Re:

Renal Medicine Assoc. Clinic, Journal Center, Phase 2, ZAP D-17

AMAFCA approves the Grading & Drainage Plan dated October 12, 2011. If you need to add a berm next to the rock swale, it won't interfere with AMAFCA access. I checked the original Journal Center Phase 2 master plan. and the ribbon channel next the North Diversion Channel acts as an access road.

C1.0
Grading Plan

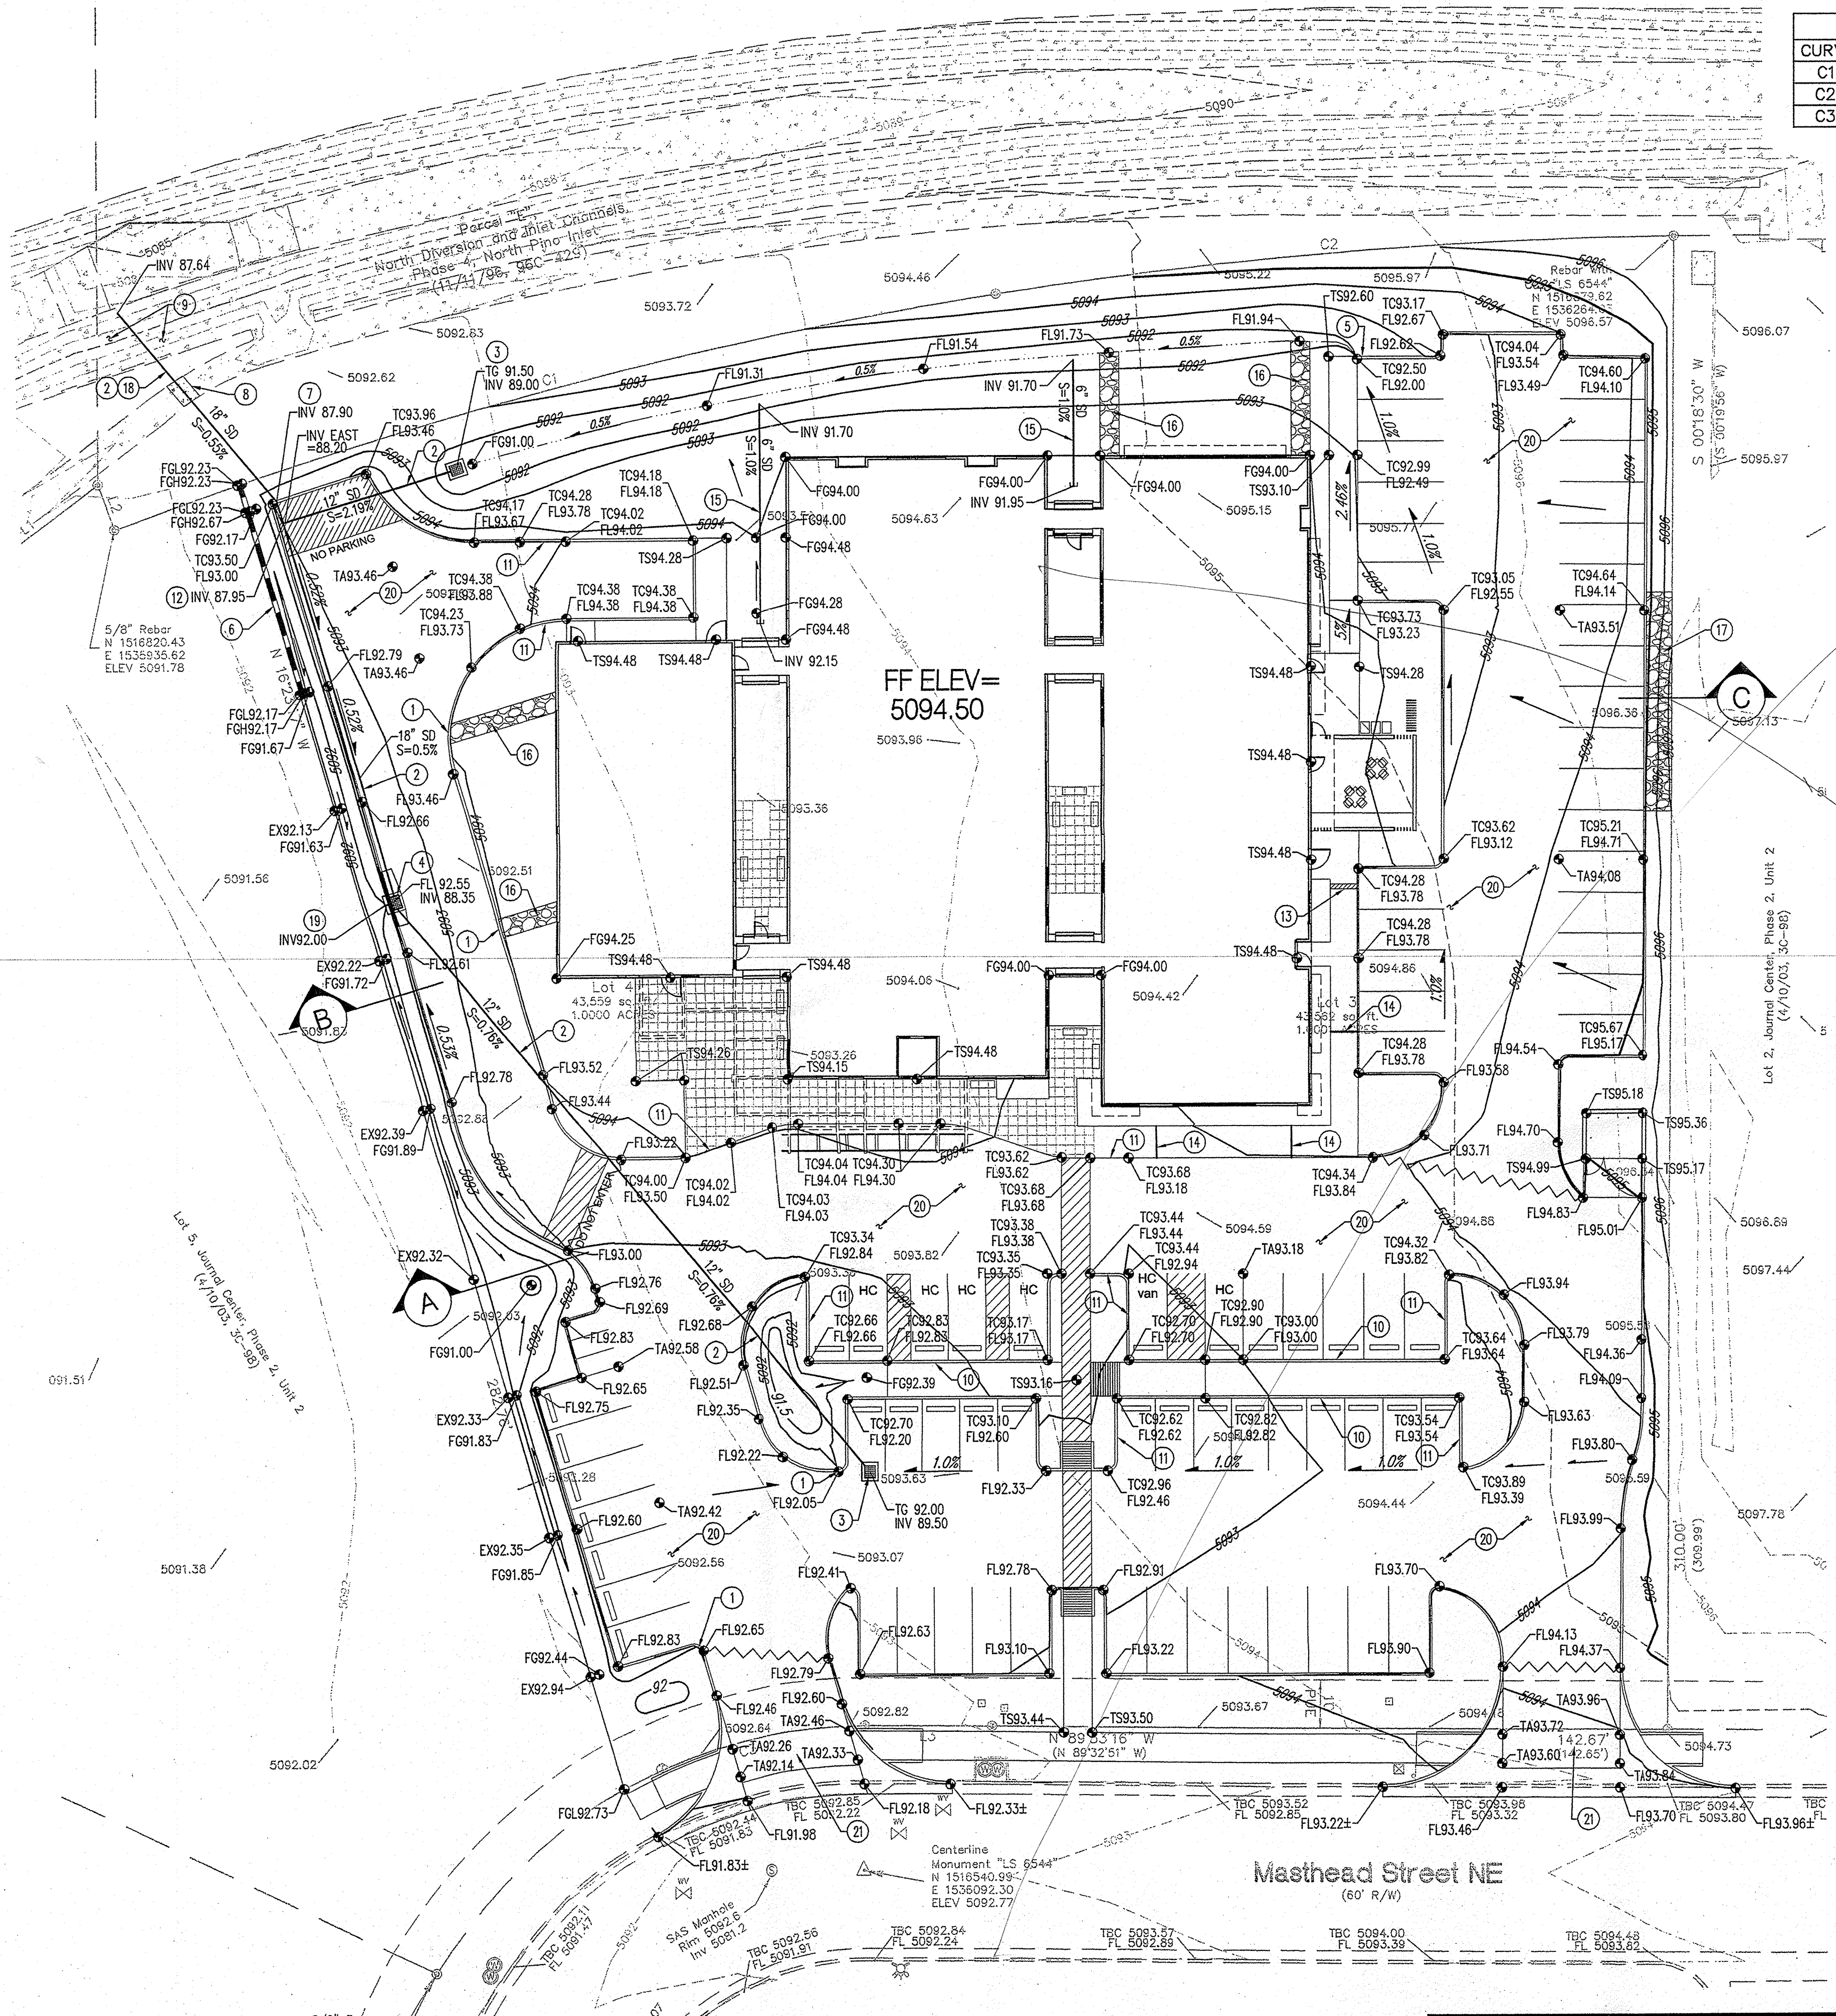
- Provide grades along the western property line so the grade of the tie slope can be determined.
- Please depress the eastern parking island.

We have revised the grading plan based on our discussion yesterday. We were able to grade a swale in the landscape area along the west property line. The revised grading also includes two small retention ponds to intercept drainage from the landscape area. This solution was proposed for two reasons:

- The outfall has changed and you are proposing a berm on AMAFCA property. AMAFCA approval is required.
- 2. The swale should be drawn to scale.
- 3. The FL is at the bottom of the rocks, not the top.
- 4. 0.3 % in rocks is more of a pond than a swale.
- 5. Why is the swale draining in reverse direction of the site in the northern portion?
- 6. It is difficult to tell if this will work with the landscape plan. a. It may be difficult to plant in the "V" of steep slopes and (b) The landscape area is irrigated. Then it rains and it spills over.
- 7. A retaining wall along the western boundary is commonly used in this application and should be considered.

AMAFCA DRAINAGE SWALE
N.T.S.

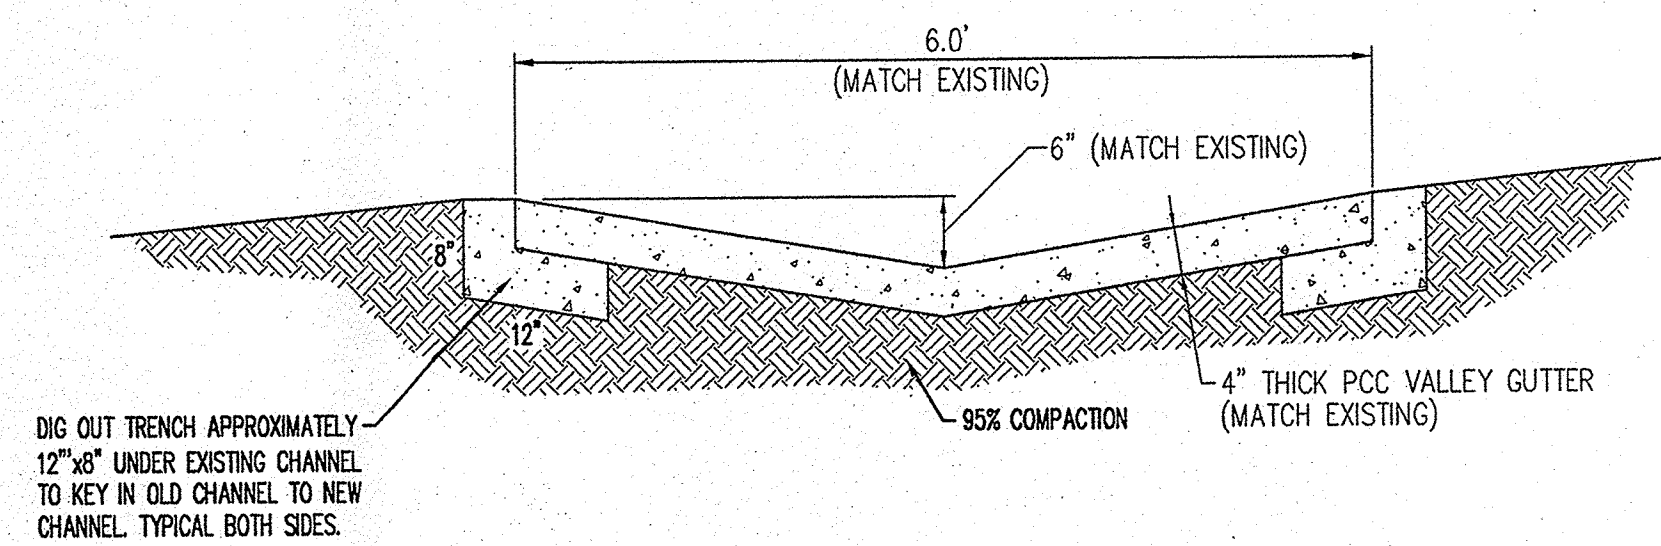
- 5. I have attached the detail for the ribbon channel as constructed with the Journal Center Phase 2 development. Note that it is only 6 feet wide. I confirmed that AMAFCA crews do not drive on it. To connect the old to new channel, dig a trench under the old channel and let concrete run under it to form a keyway.

PIPE PENETRATION (PLAN VIEW)
NO SCALE

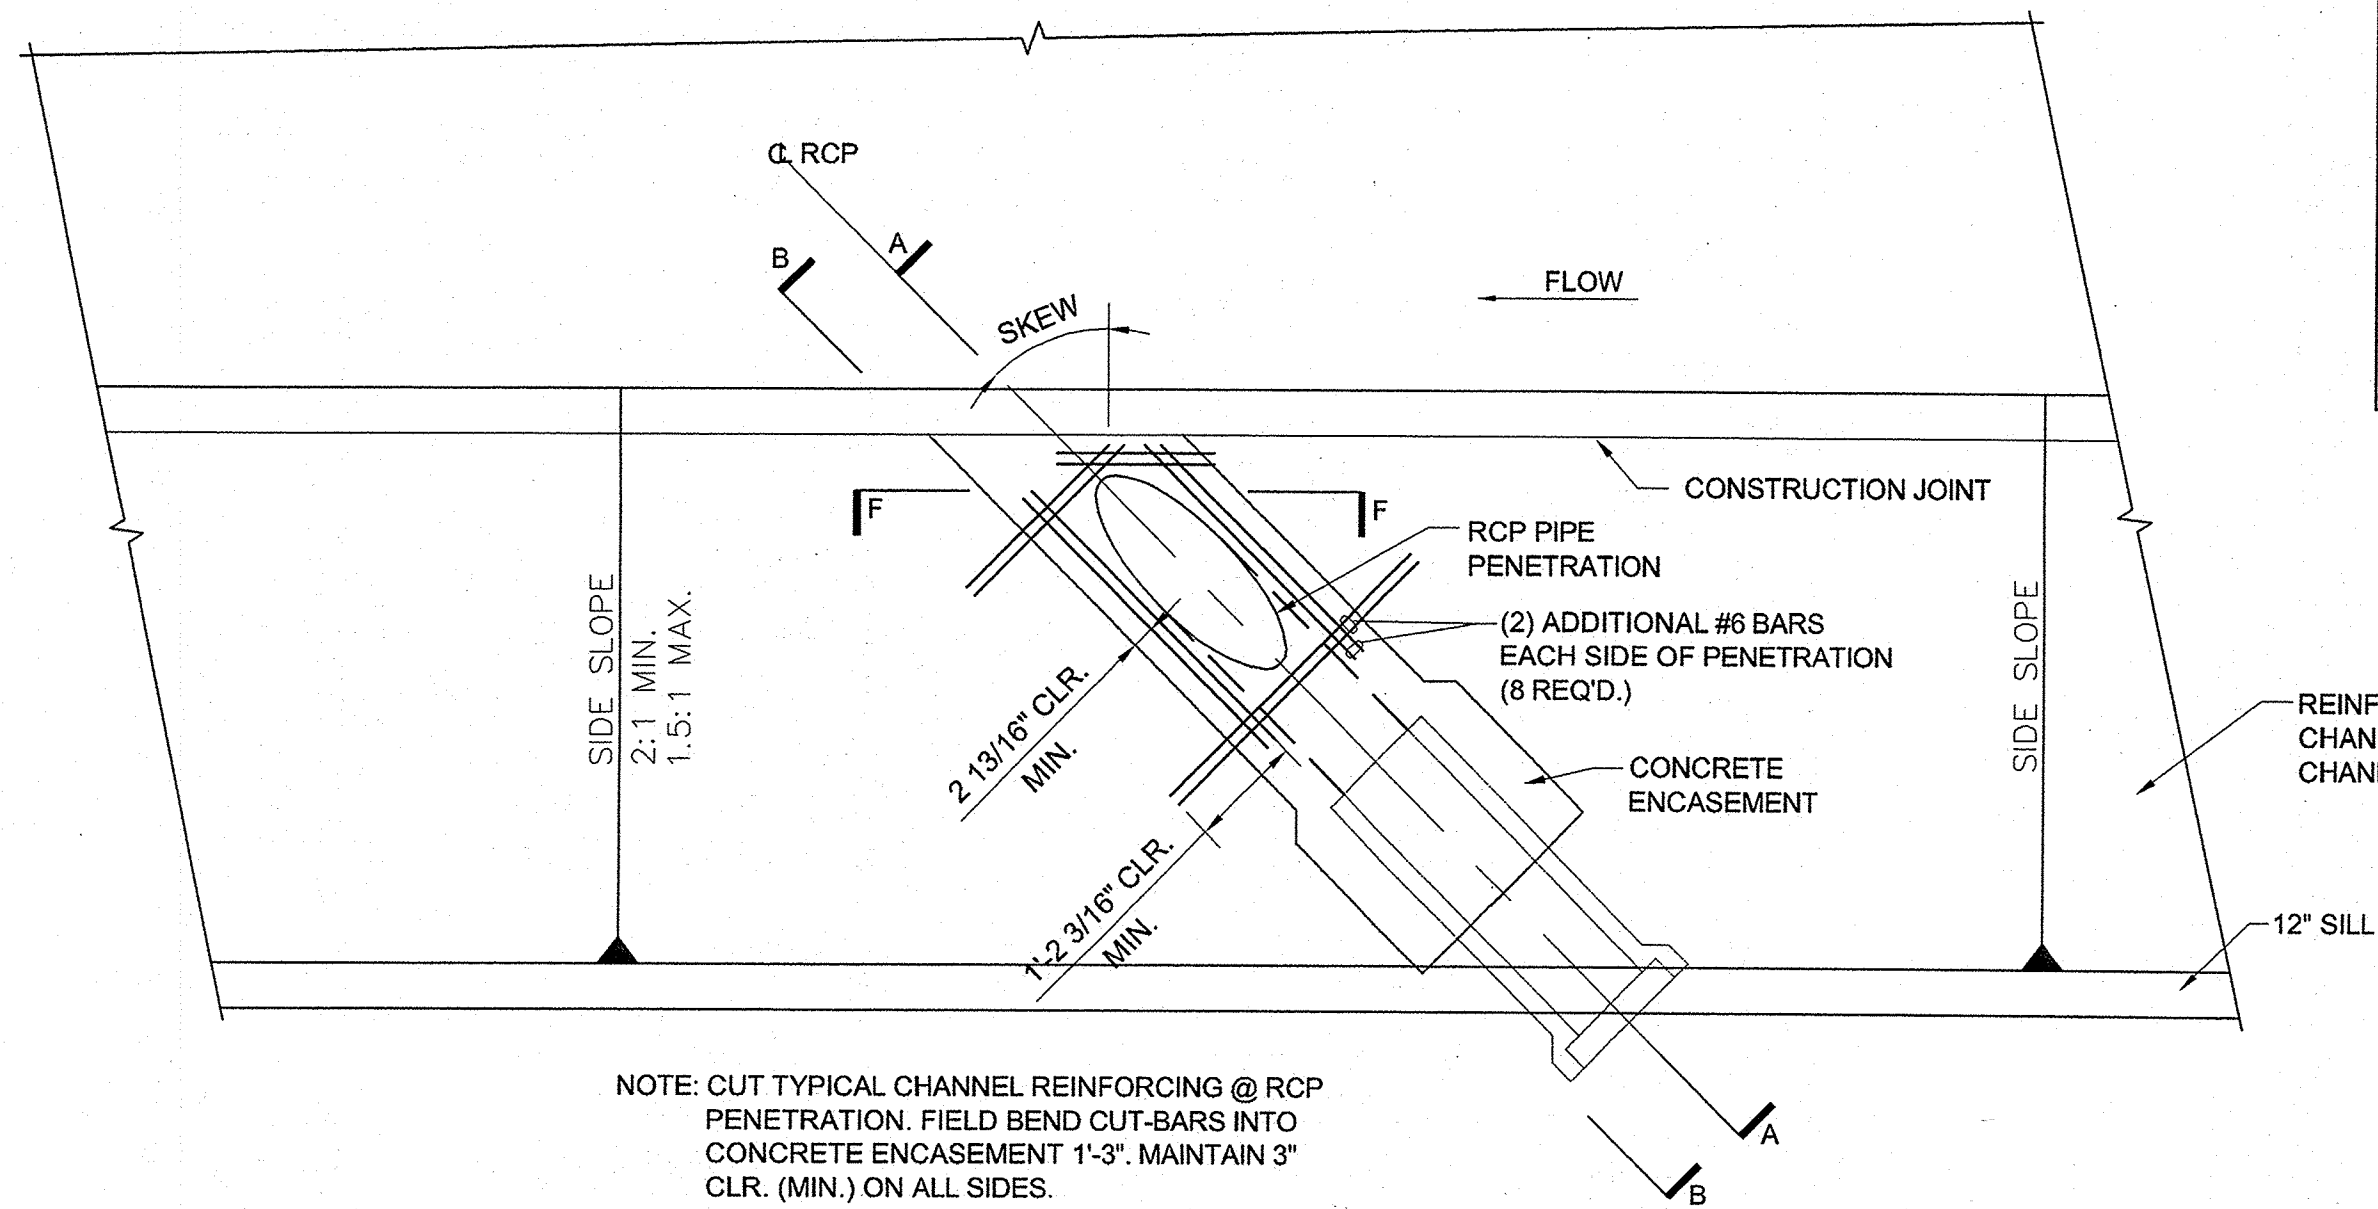
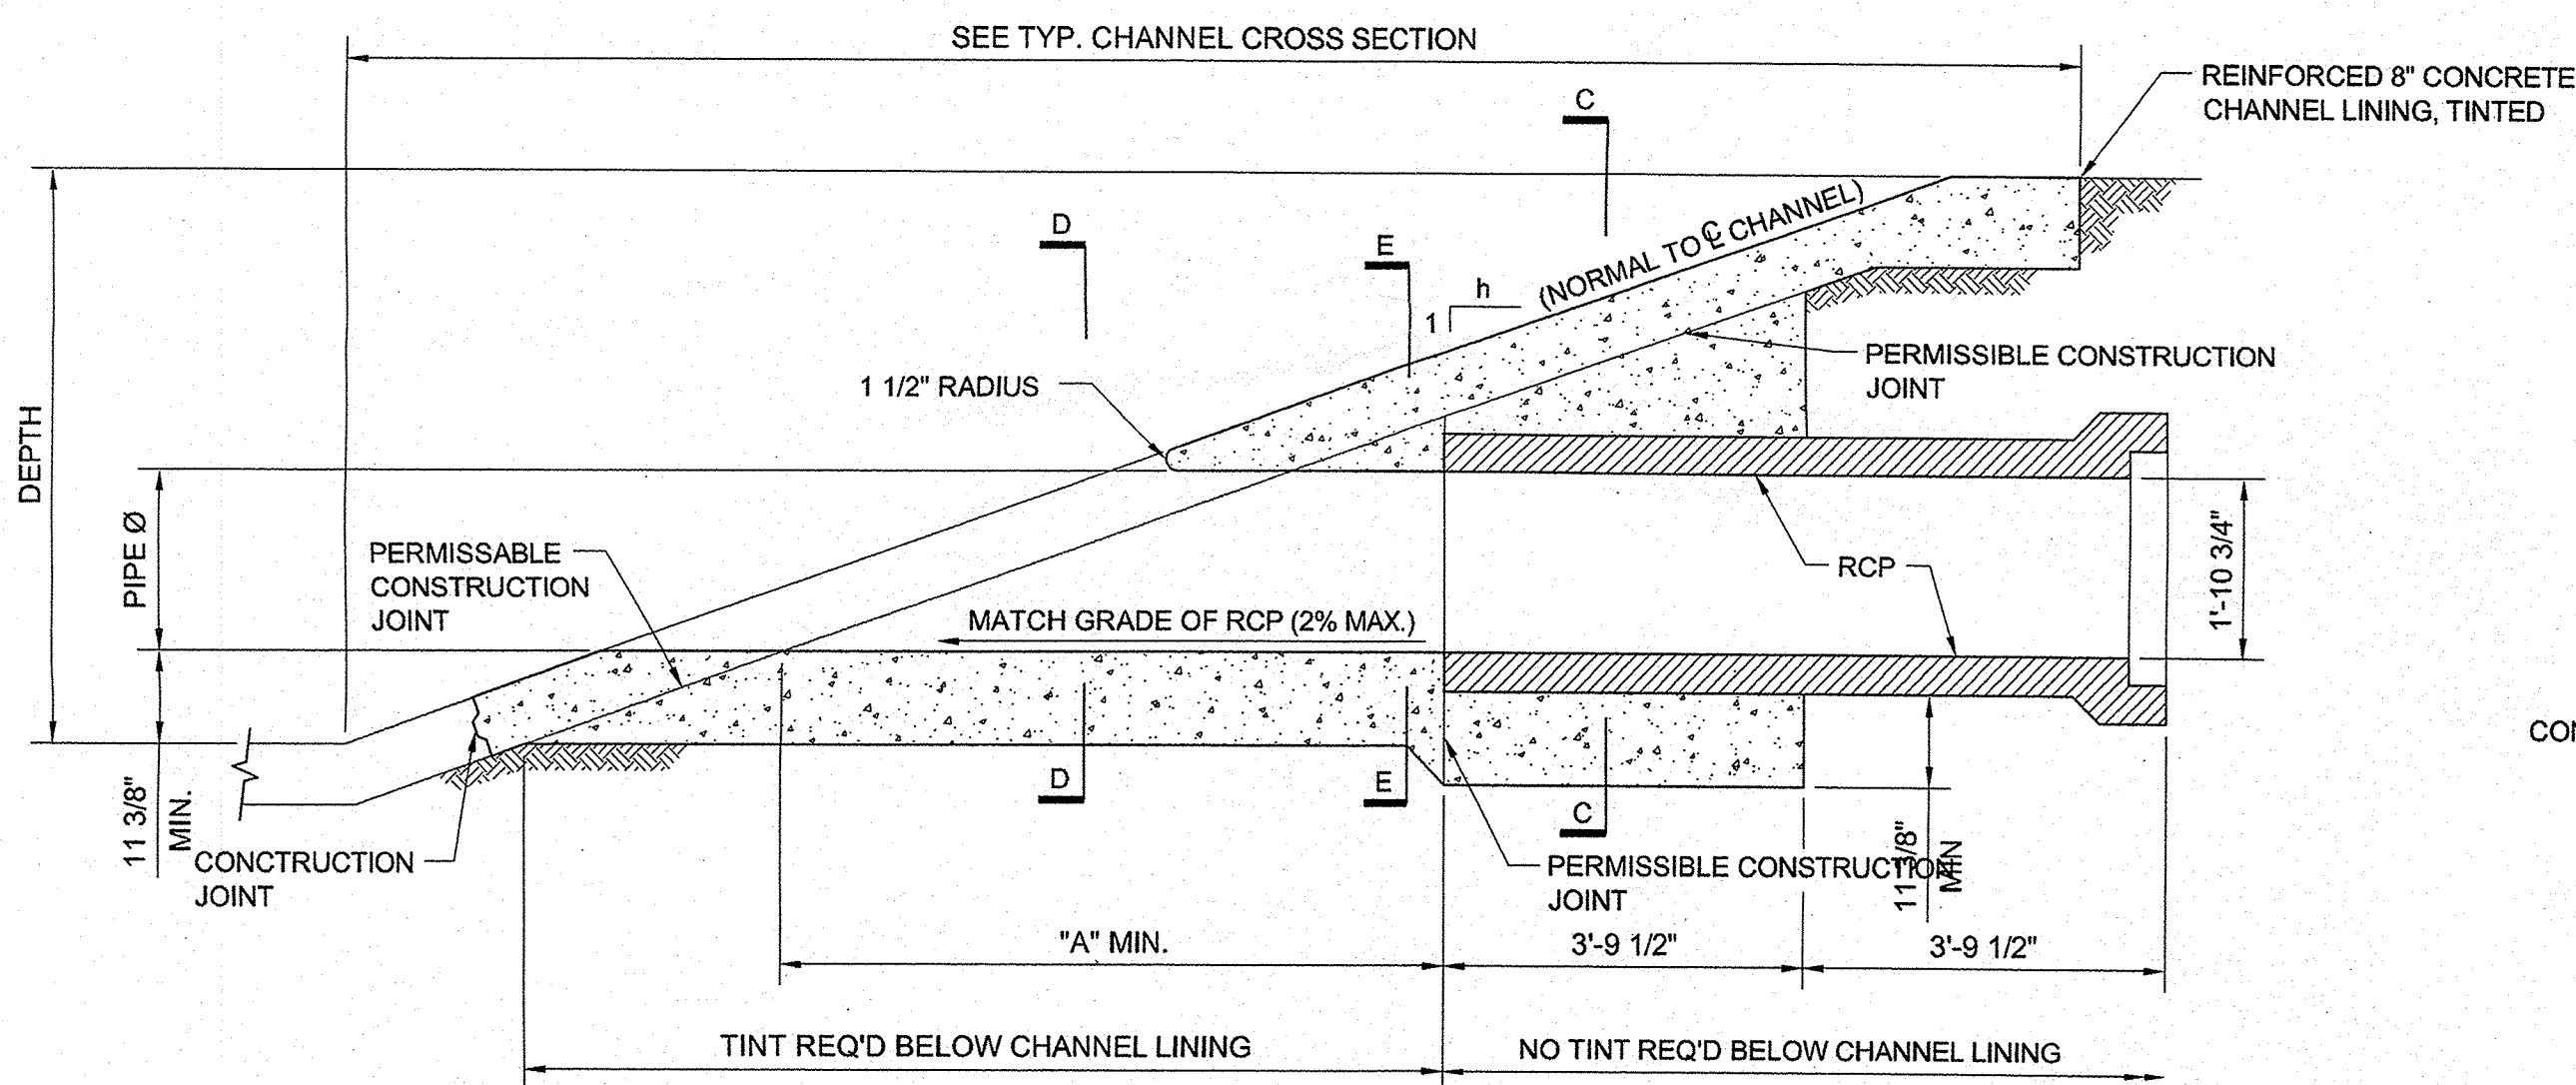
- 3. The pipe will enter the channel on the side of the existing rundown. If it must enter the channel at an angle, it should be pointed downstream. If you must remove and replace the rundown, it will be constructed to our current attached detail.

- 4. I have also attached our standard detail for a pipe penetration 12" or less in diameter. If it is larger, we have another detail for 24" and larger. If you need to vary the side slopes of the cut in to the channel, I will discuss it with Kurt Wagener, AMAFCA Field Engineer.
